Your Ref: OWPC23978
Our Ref: K/19/19/HH 25-06-2019
Please ask for:
Zac Denton

Two storey rear extension with a small canopy projecting the footprint to the front.
Demolition of existing living room and additional first floor for habitable use with alterations to fenestration.

Little Tangleway Middle Way Kingston Gorse East Preston

Thank you for your internet representation made on 8th August 2019 which has been recorded as '**an objection**' with the comments as follows:

Proposed Site Plan/Roof Plan
Scale 1:200

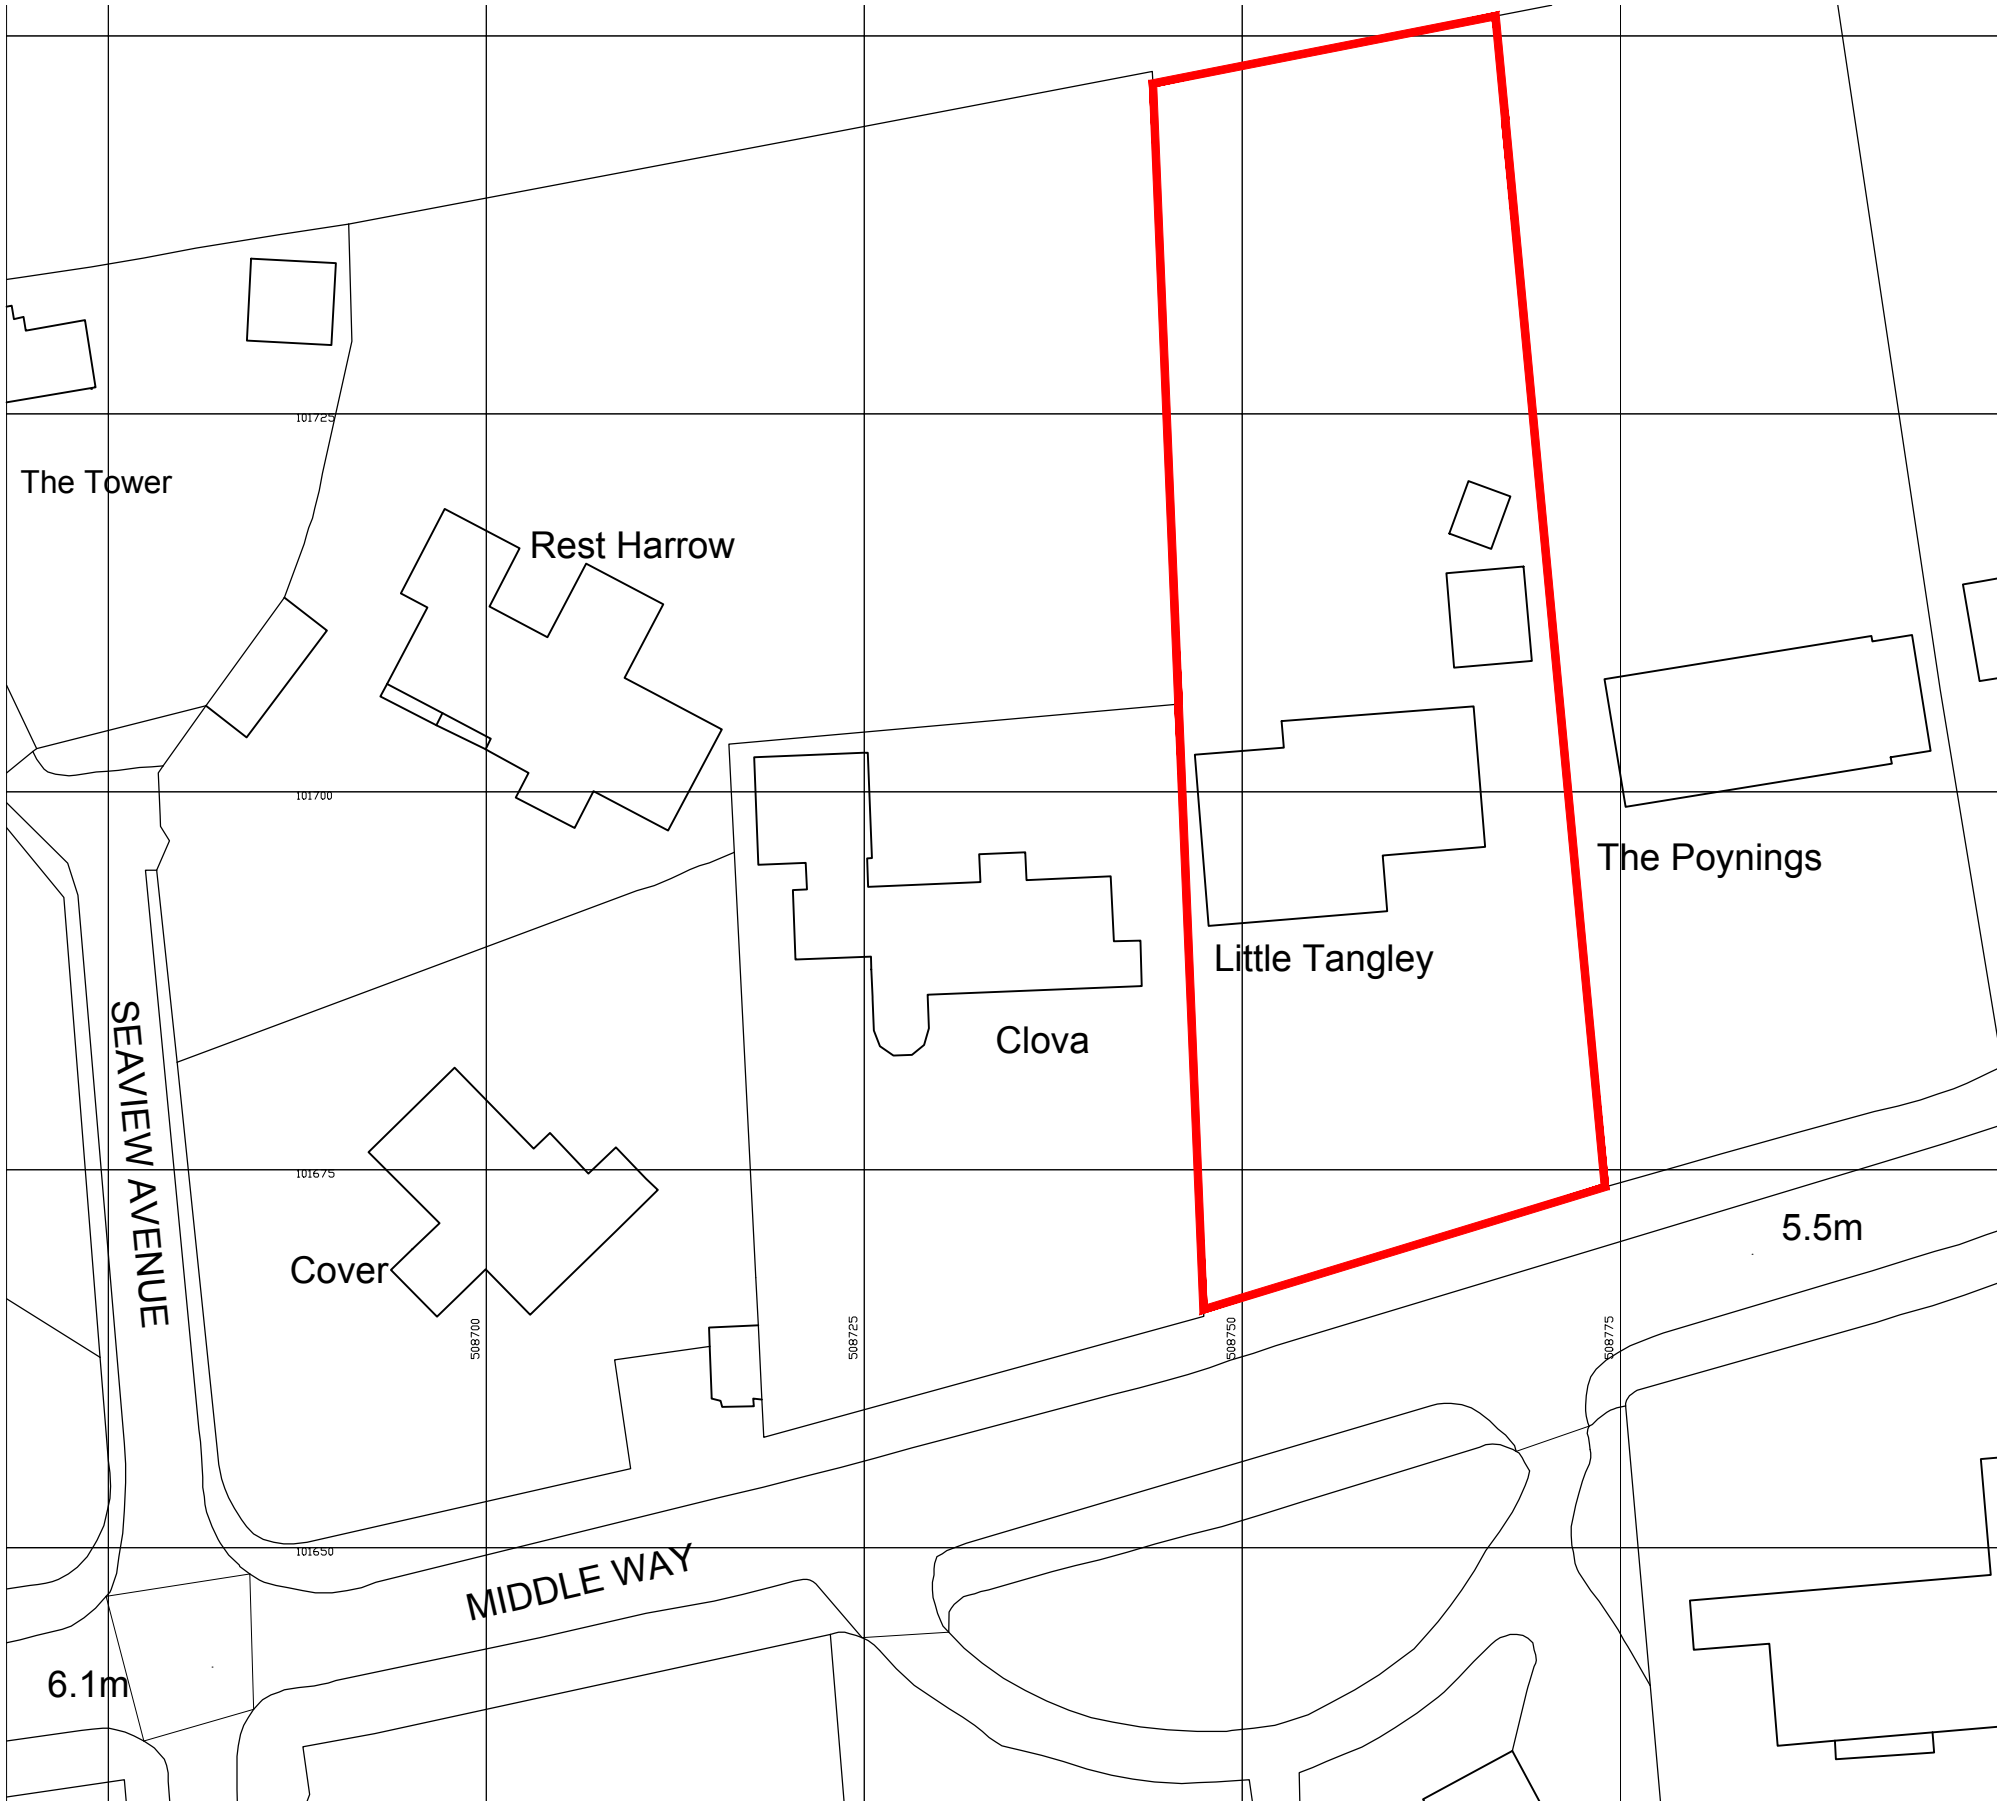
The proposal also features a slate roof. The predominant roofing material in the area is the clay tile, though Horsham stone is used on the house opposite this site. This feature of the design contravenes Policy D DM1 (1).

Drawing Title
Proposed Sections

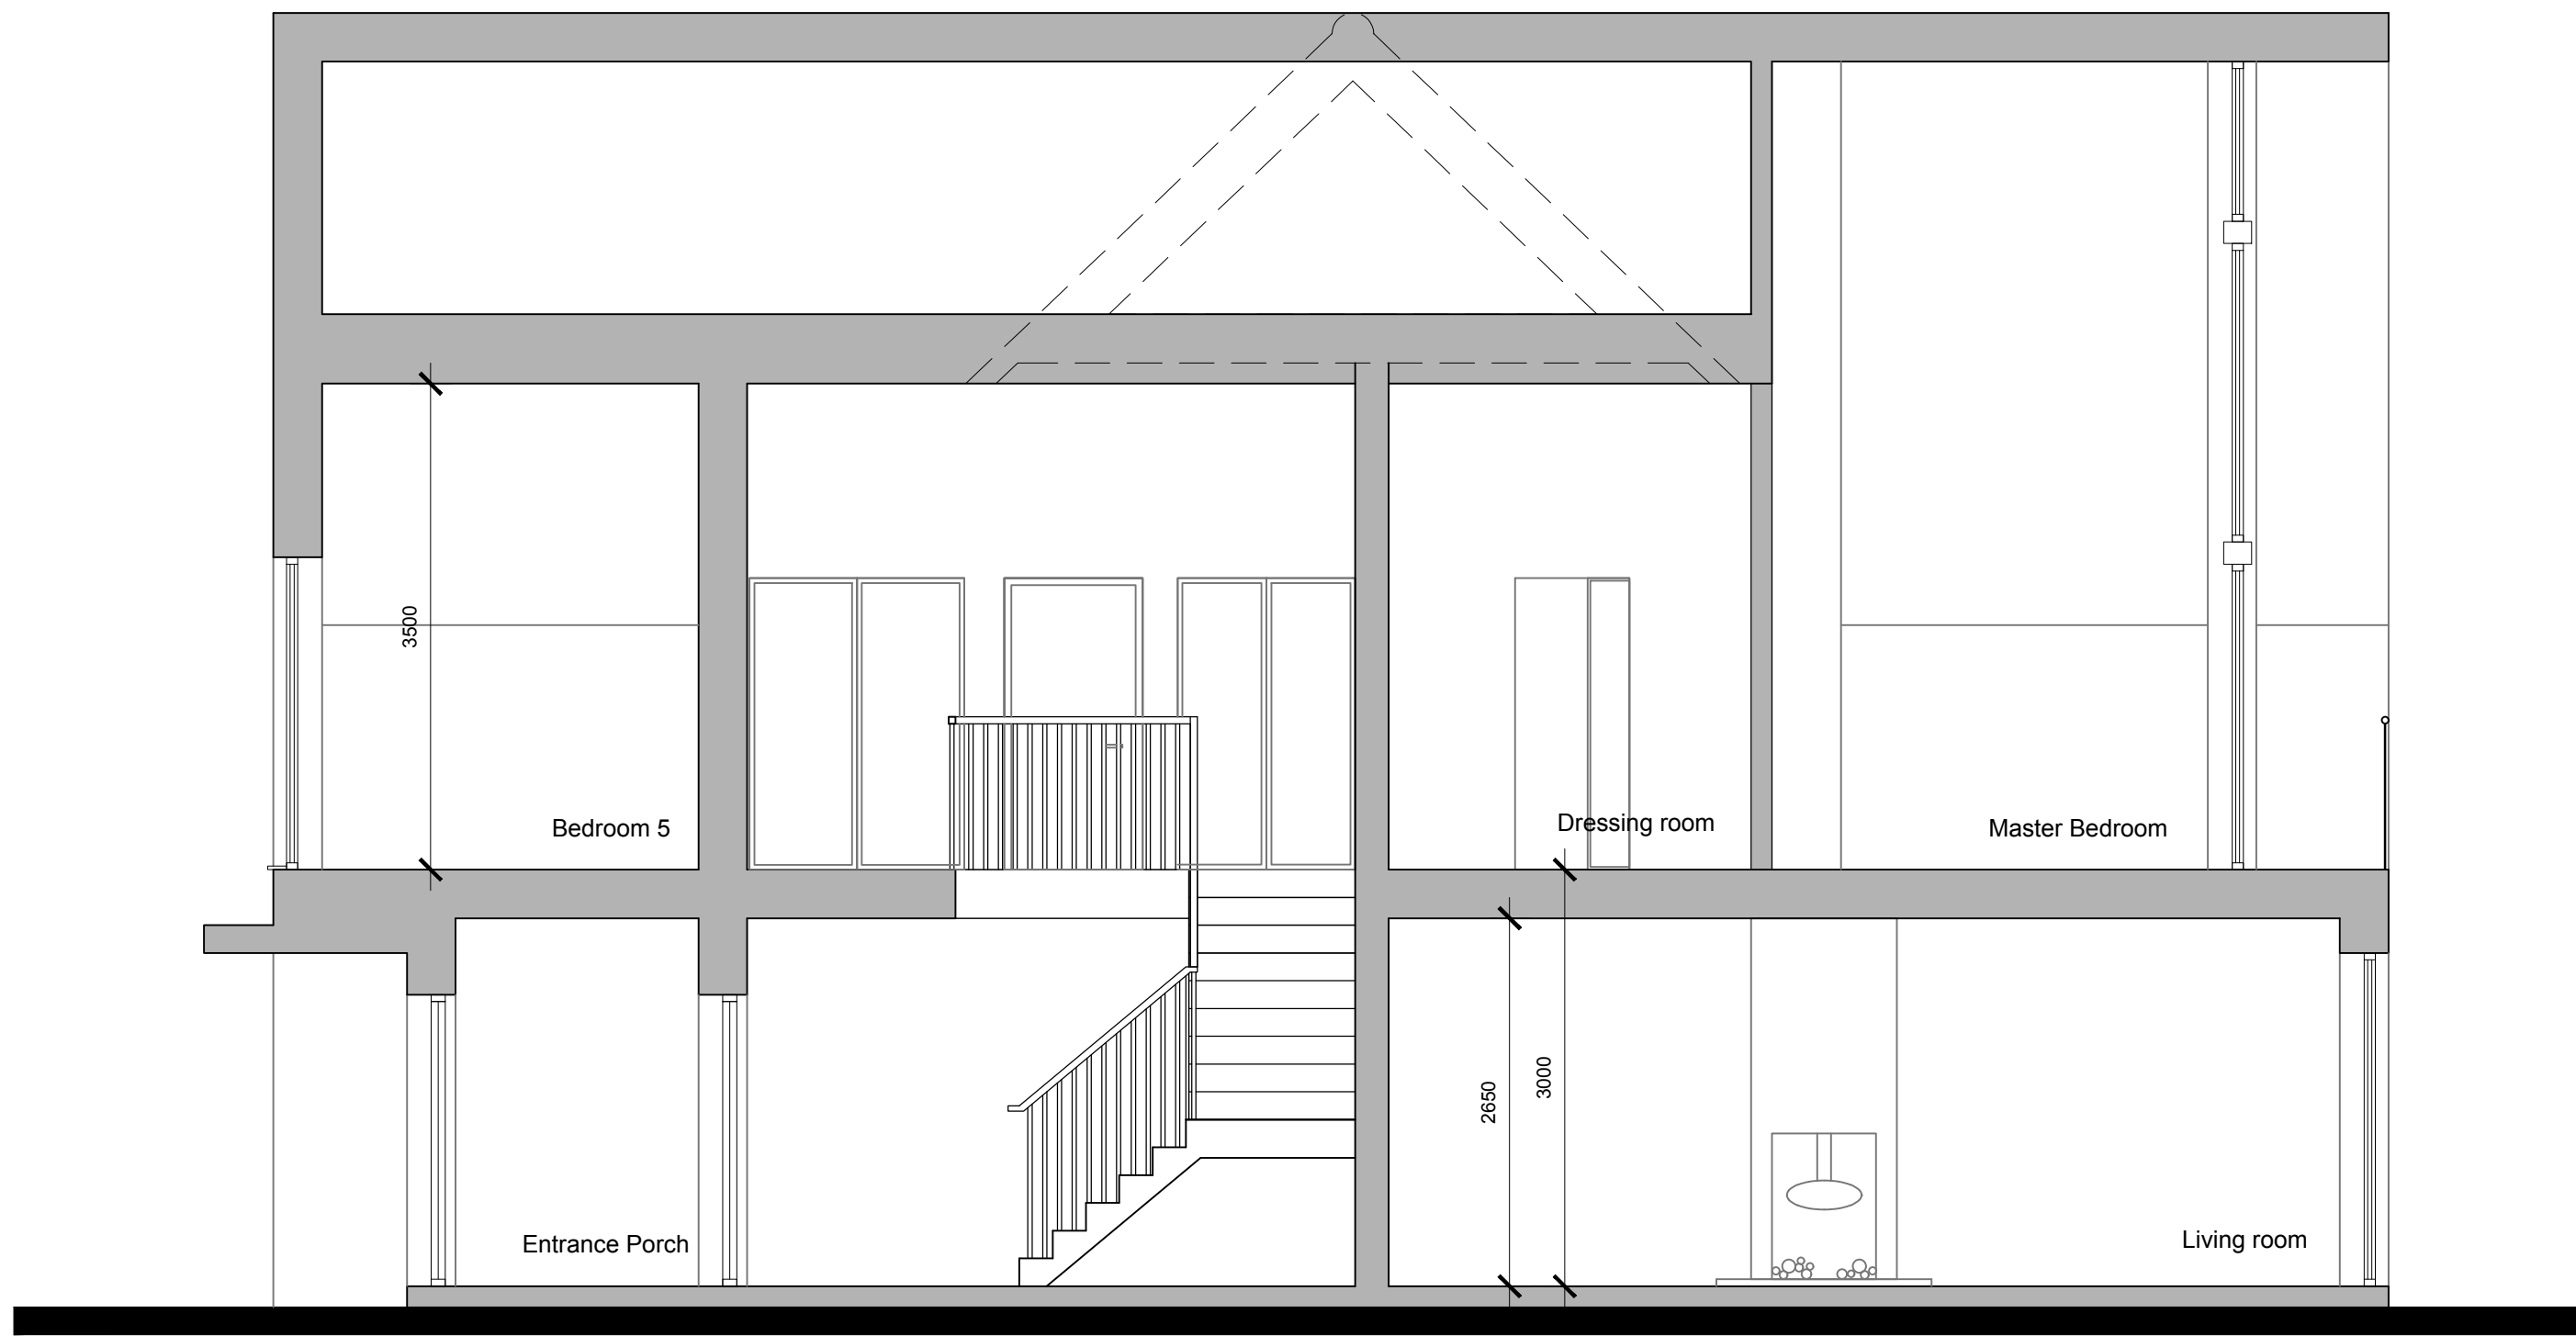
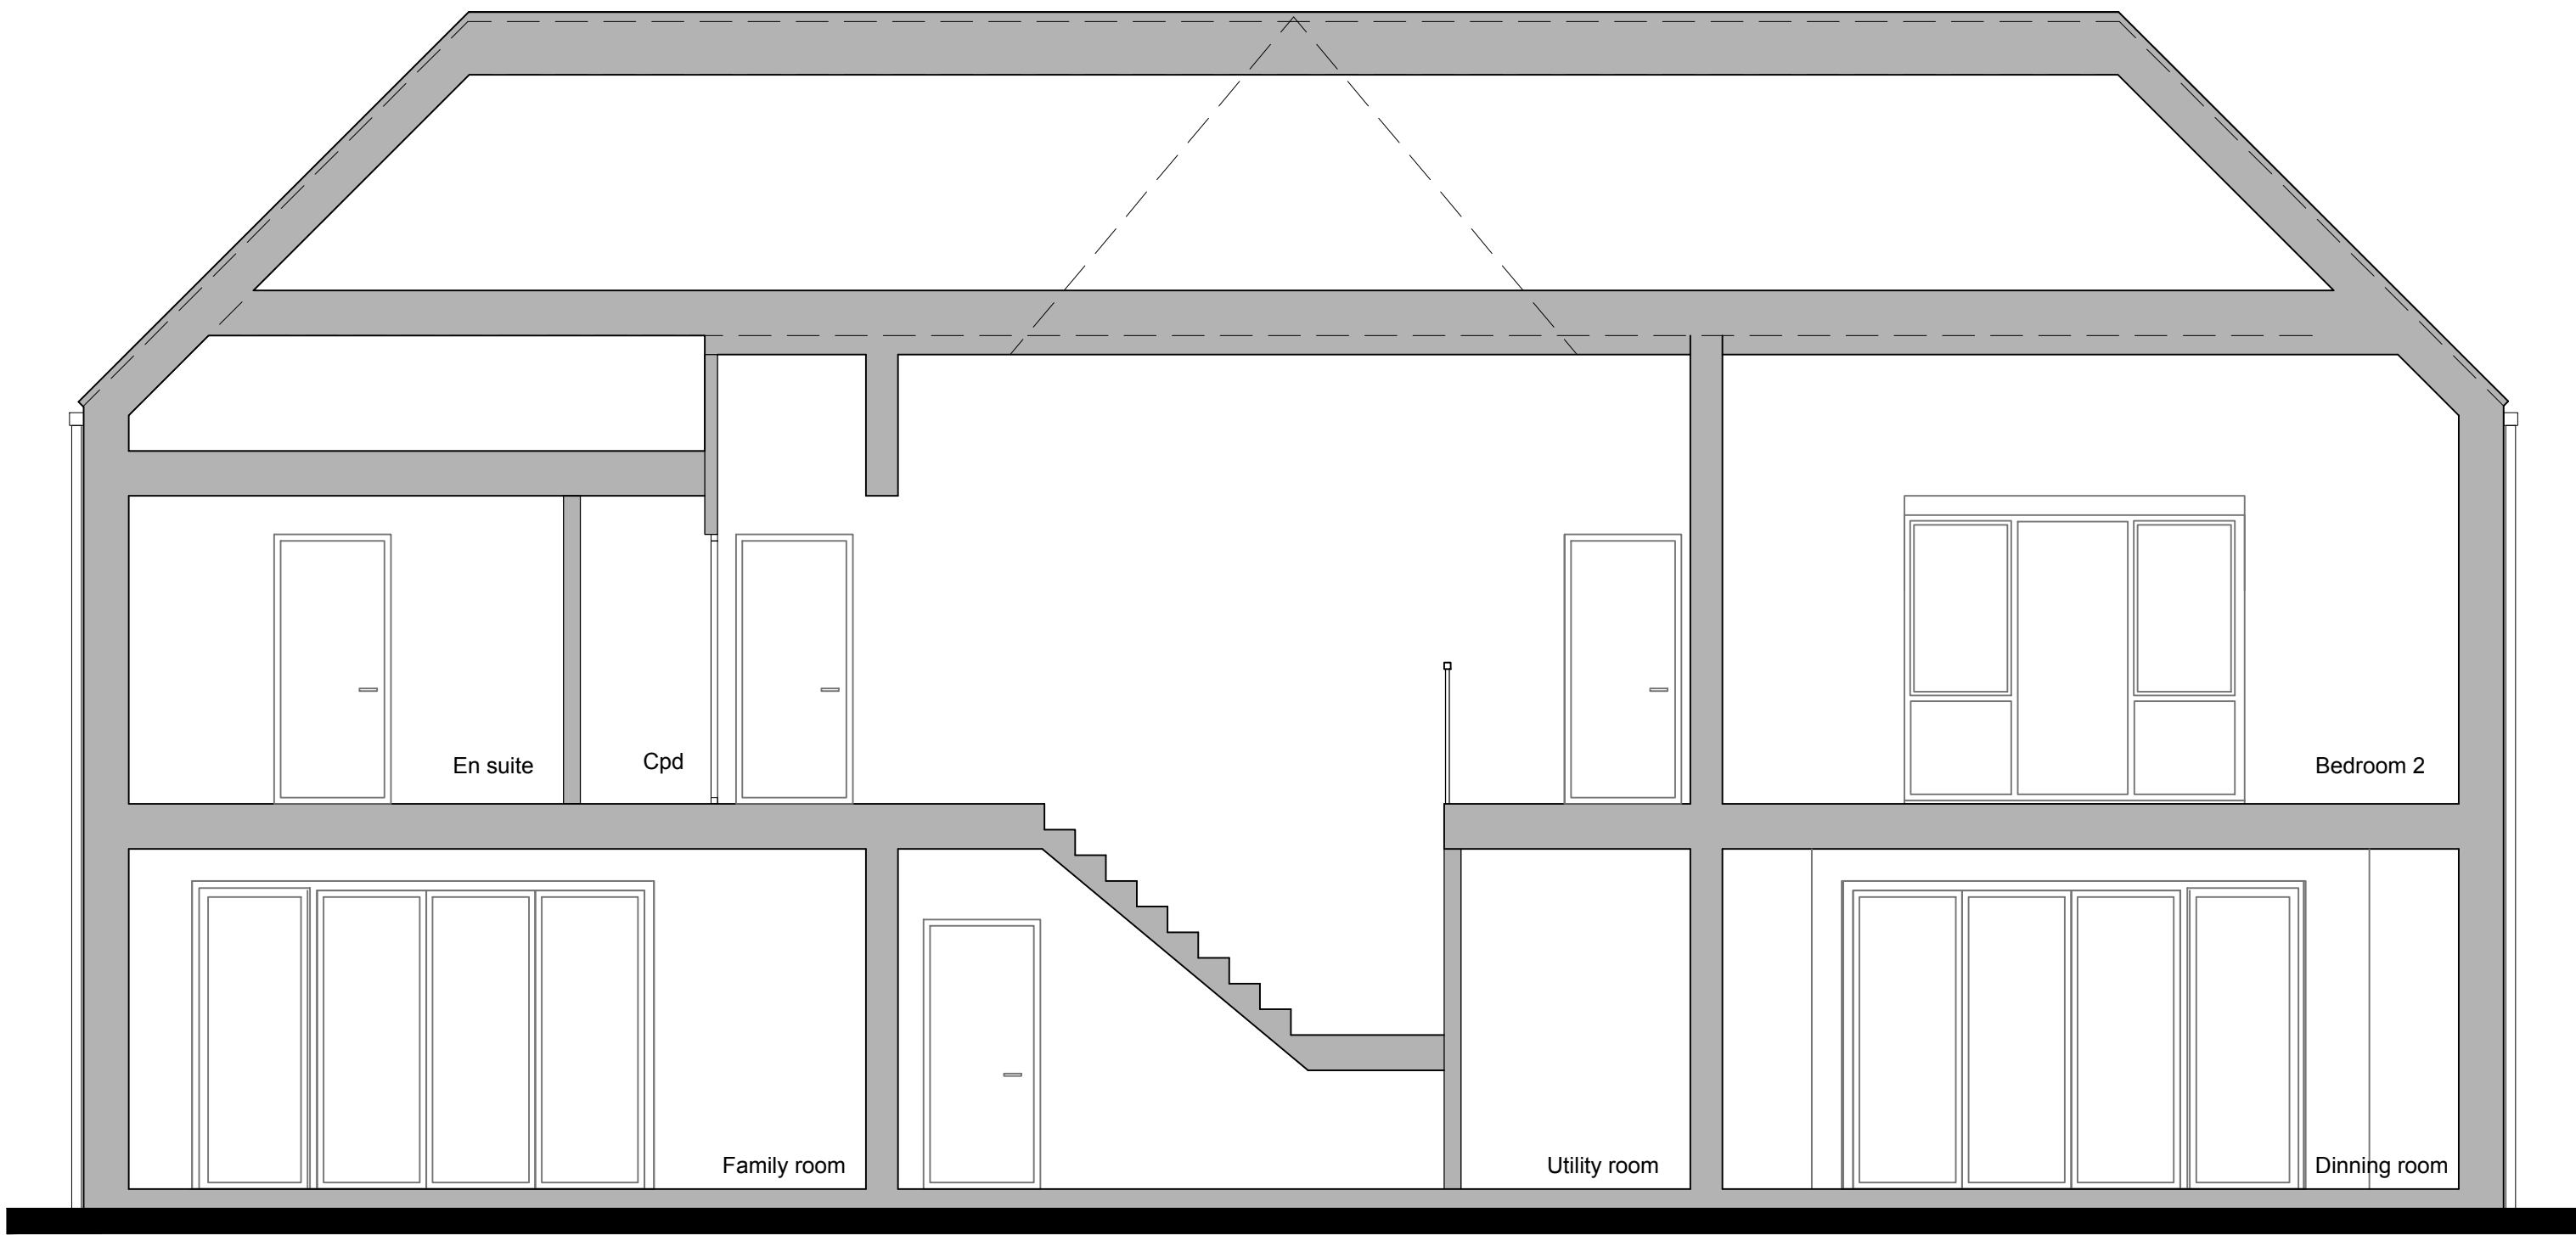
This proposal would convert a bungalow into two-storey house. This major change would create overshadowing and overlooking of the neighbouring houses. This feature of the proposal contravenes Policy D DM4 (c) of the Arun Local Plan.
